KIRKLEES METROPOLITAN COUNCIL INVESTMENT & REGENERATION SERVICE

DELEGATED DECISION TO DETERMINE PLANNING APPLICATION FOR ADVERTISEMENT CONSENT

Reference No:	2025/64/92472/W
Site Address:	Part of former St Luke's Hospital site, Blackmoorfoot Road, Crosland Moor, Huddersfield, HD4 5RA
Description:	Erection of illuminated signs
Recommending Officer:	Joshua Merriman

DECISION – Advertisement Consent - Granted

project
Blackmoorfoot Road
Huddersfield
drawing title
Proposed Lidl Canopy Logo
Sign Details

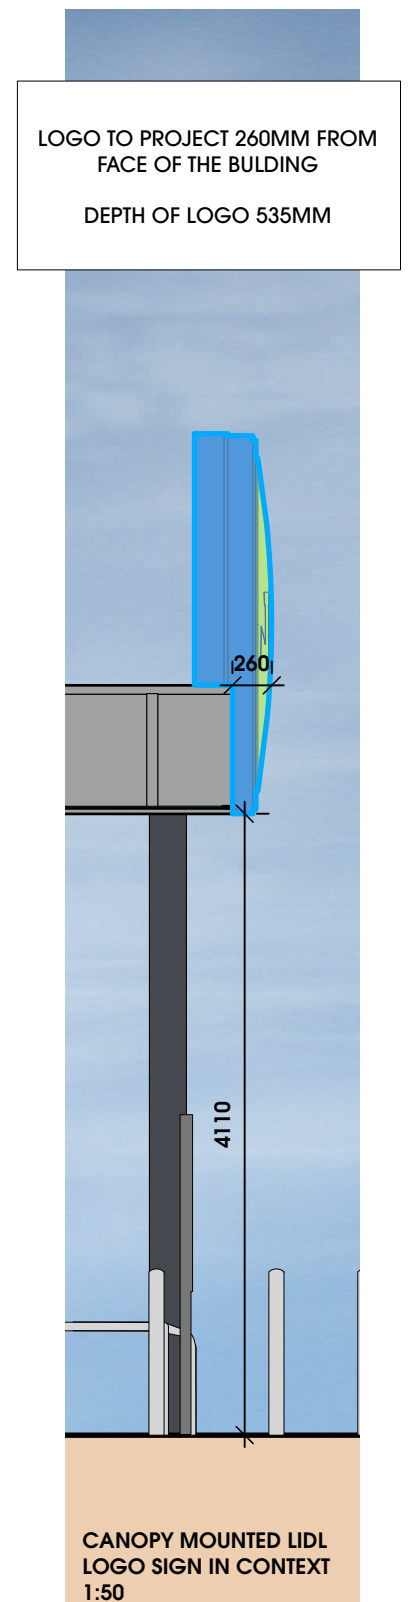
The dimensions of the two proposed fascia (canopy logo signs) are detailed below:

- Height: 2.5m.
- Width: 2.5m.
- Depth: 0.535m.

The signs will be internally illuminated at an illuminance level of 85cd/m², therefore, this falls within the acceptable illuminance levels for the area of the proposal. The proposed fascia/canopy logo signs are considered to be of an acceptable size and design that is consistent with the surrounding street scene and character of the local area.
